Application by East Anglia ONE North Limited for an Order Granting Development Consent for the East Anglia ONE North Offshore Wind Farm and by East Anglia TWO Limited for an Order Granting Development Consent for the East Anglia TWO Offshore Wind Farm

Requests for further information and written comments

Questions under EPR Rule 17 (R17QF)

Issued on 18 June 2021

Appendix 1: Figures

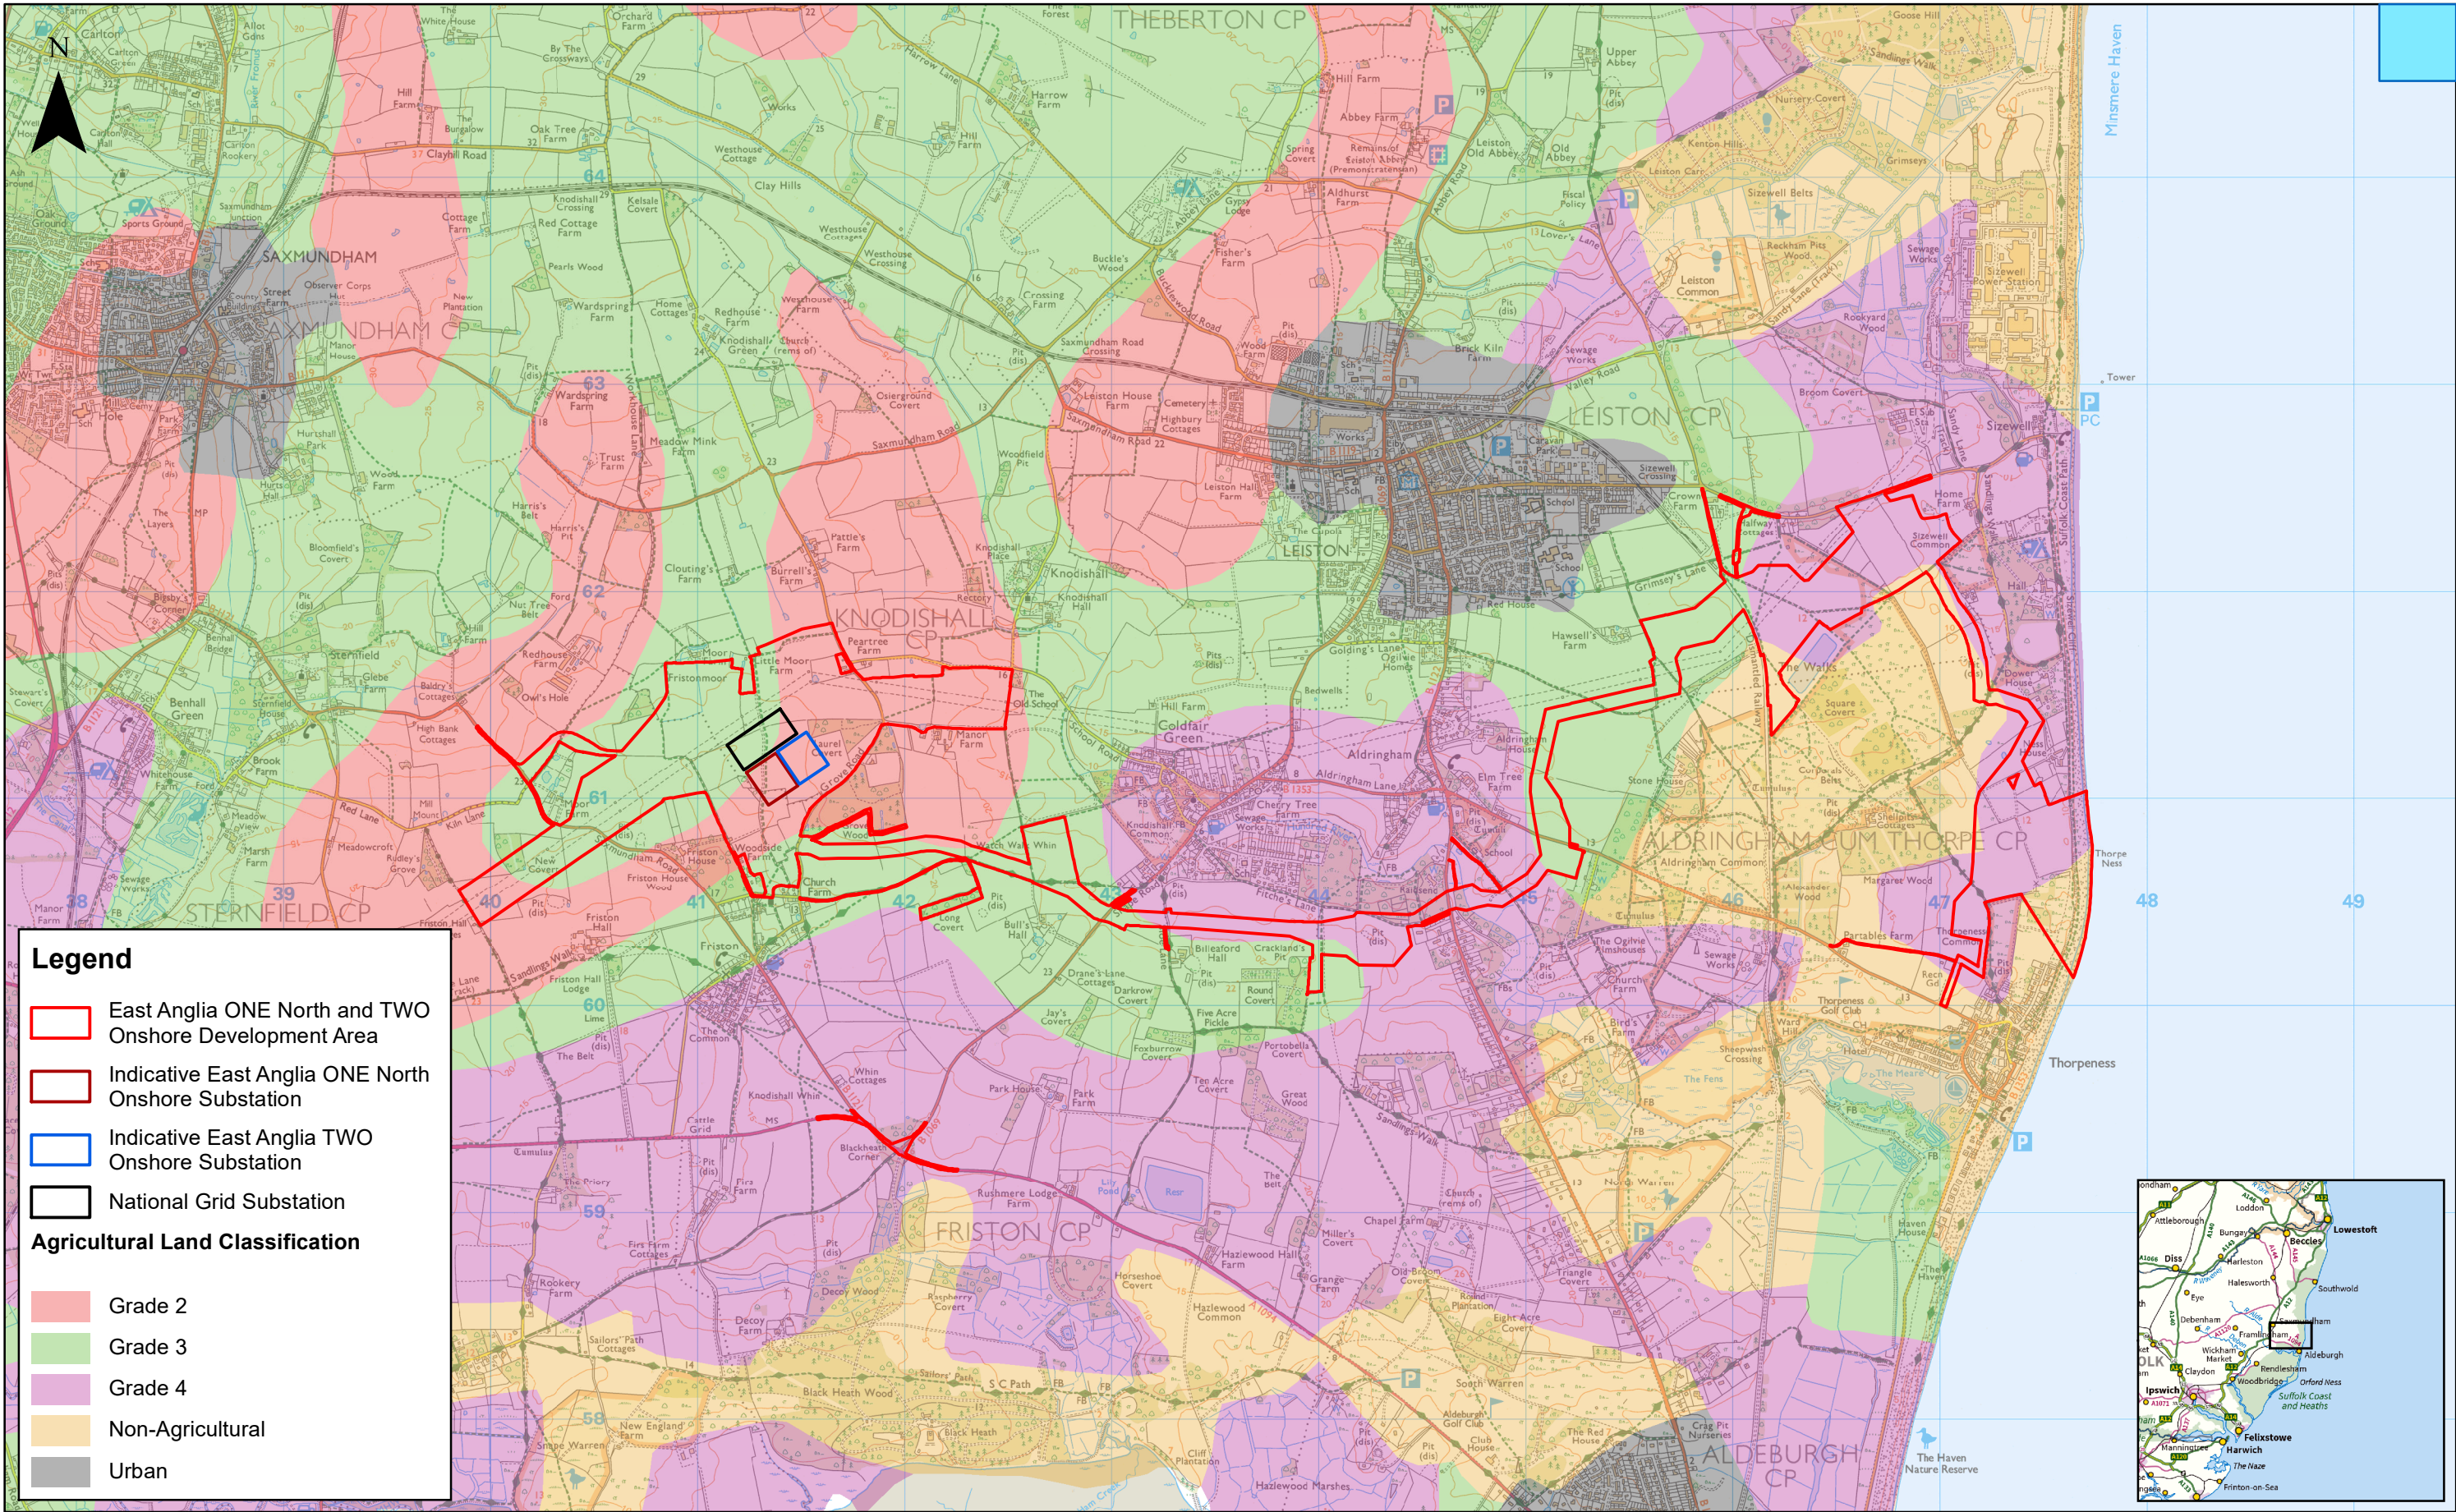
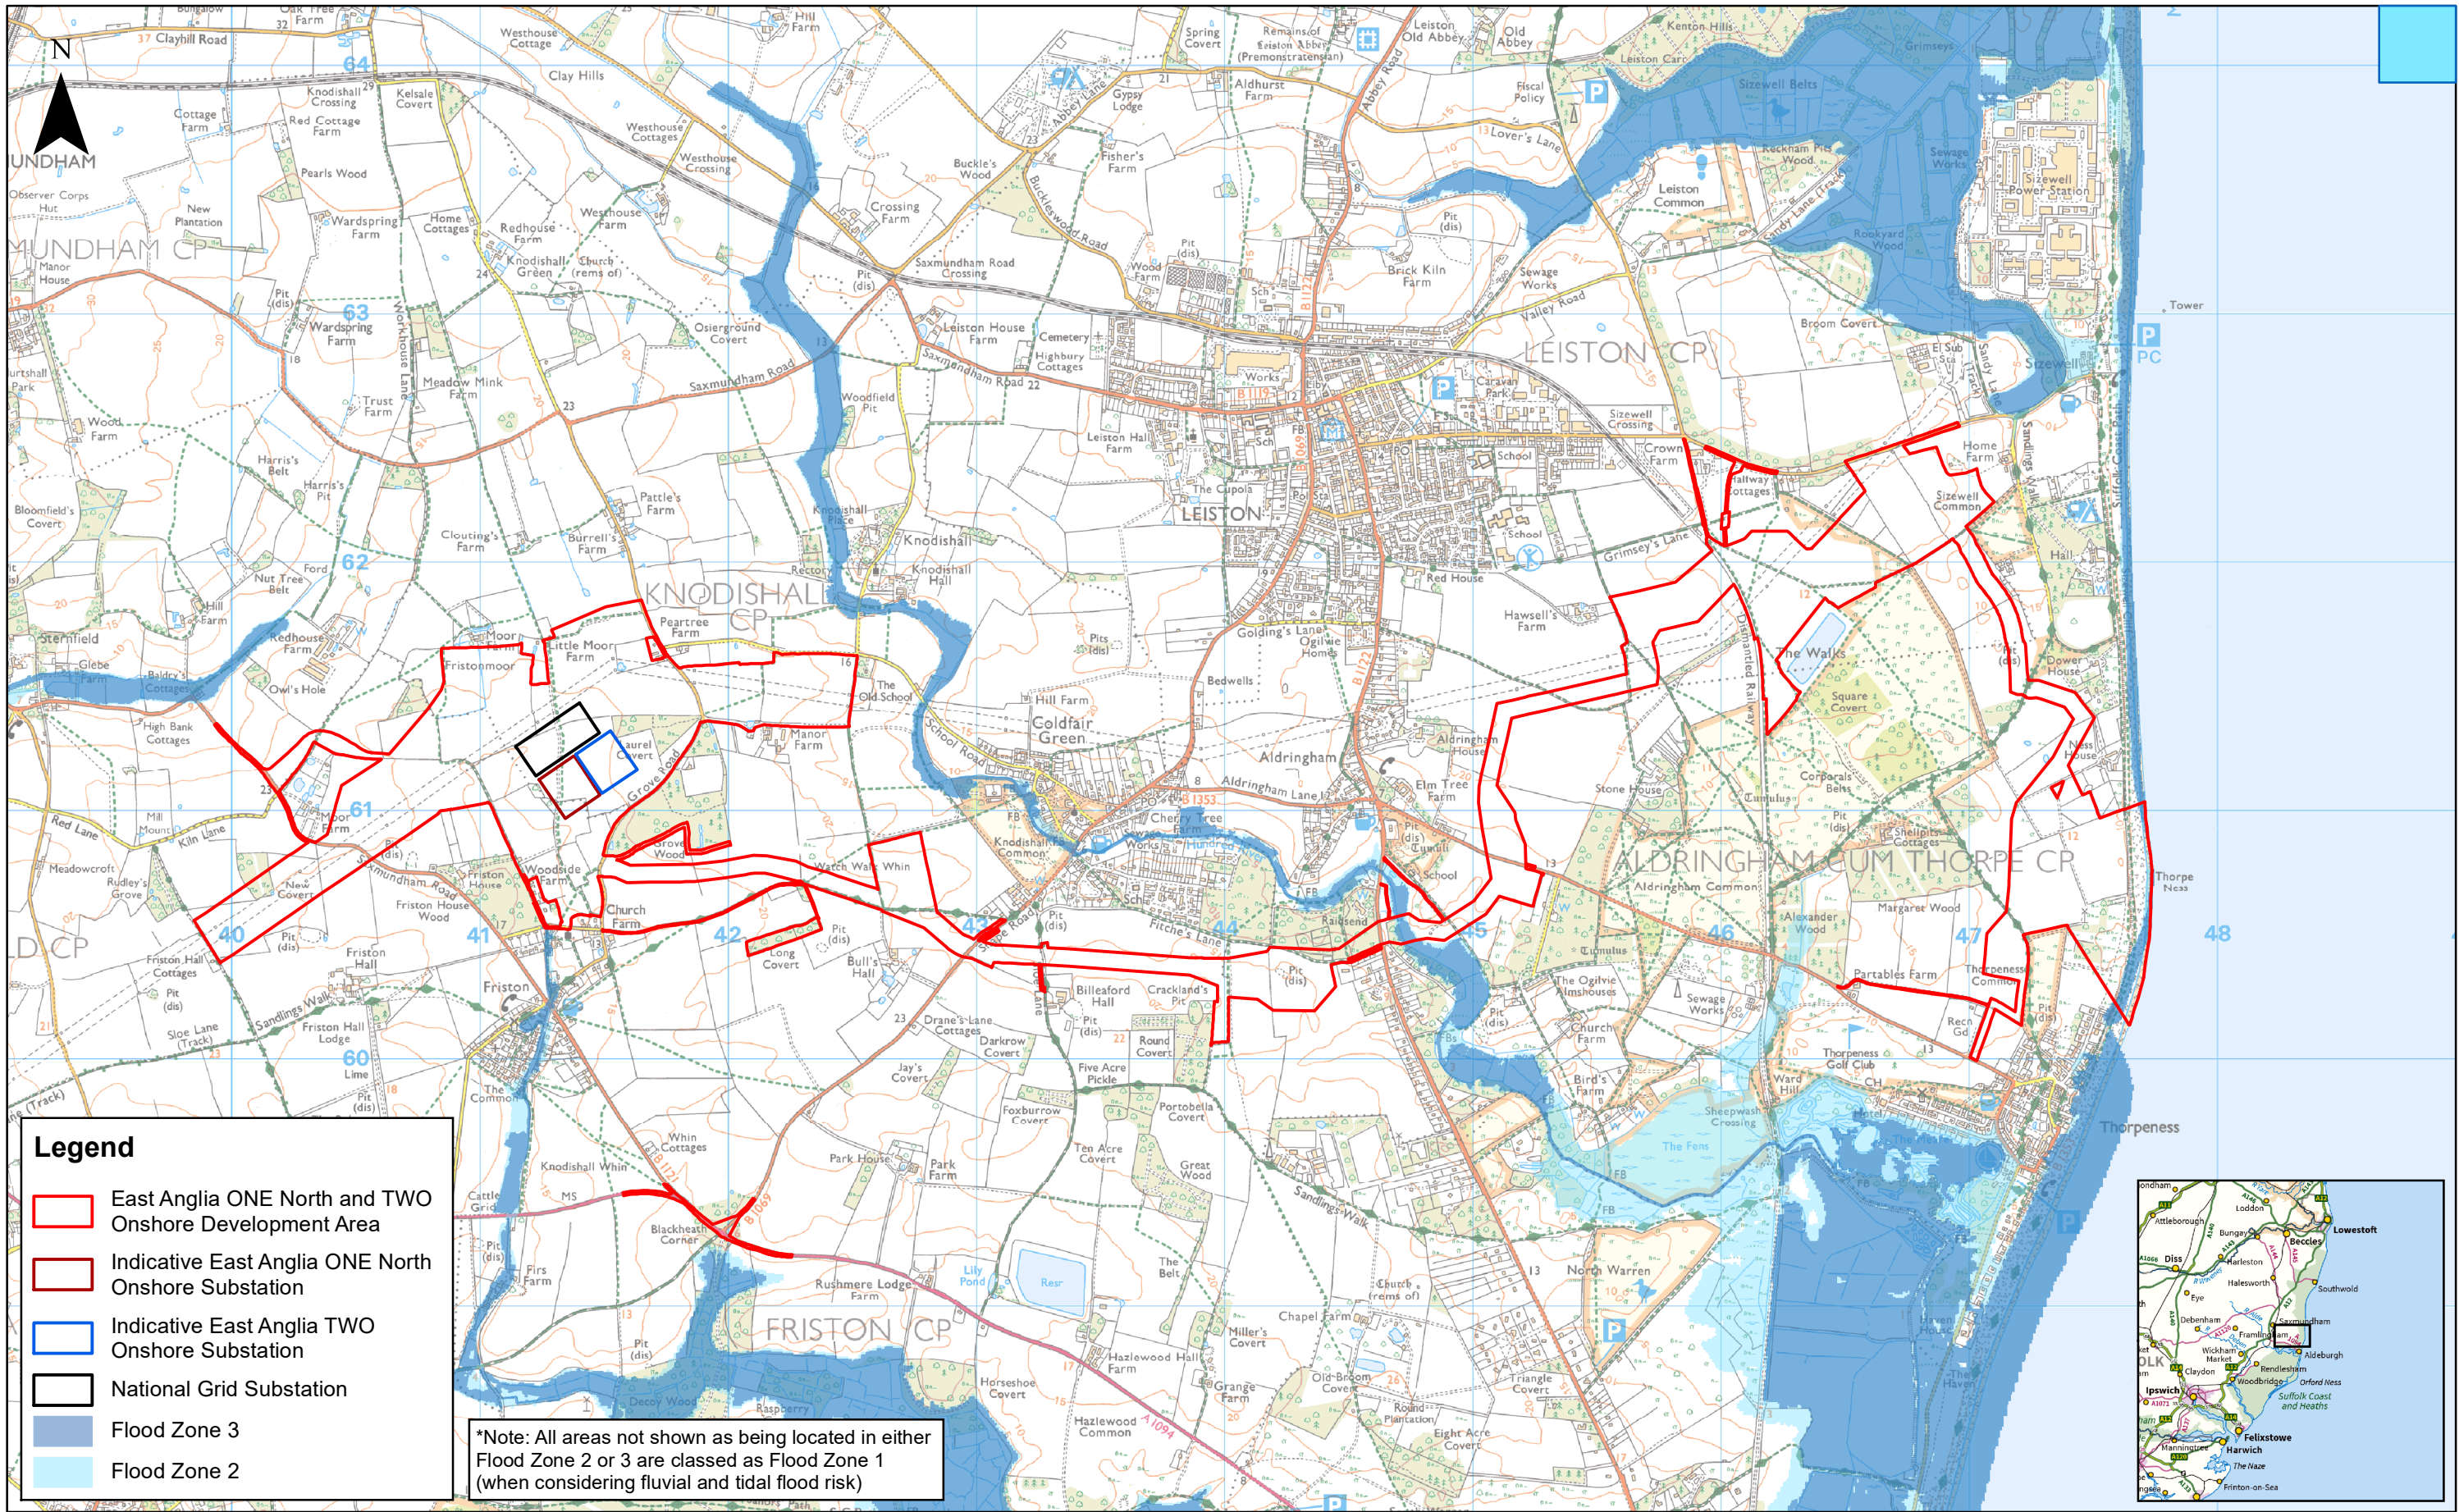
Onshore Substation Siting and Design				
R17QF.5	SCC	1	2	<p>Land Plans and Appendix 2 of the Outline Operational Drainage Management Plan (OODMP)</p> <p>Appendix 2 of the updated OODMP [AS-125] shows the order limits in relation to the SuDs basin alternative outfall on Church Lane. Are you content that the order limits shown in Appendix 2 correspond with those shown on Sheet 7 of the Land Plans?</p>
R17QF.6	SCC, Environment Agency	1	2	<p>Maintenance of the Friston Watercourse</p> <p>Paragraph 140 of the OODMP [AS-125] states that additional inspection or maintenance works required on the Friston watercourse due to the projects will be addressed by way of an agreement with the Environment Agency prior to commencement of Work Nos 30 and 41.</p> <p>To SCC:</p> <ul style="list-style-type: none"> Does this satisfy your concerns in relation to this matter and is there sufficient detail within the OODMP?
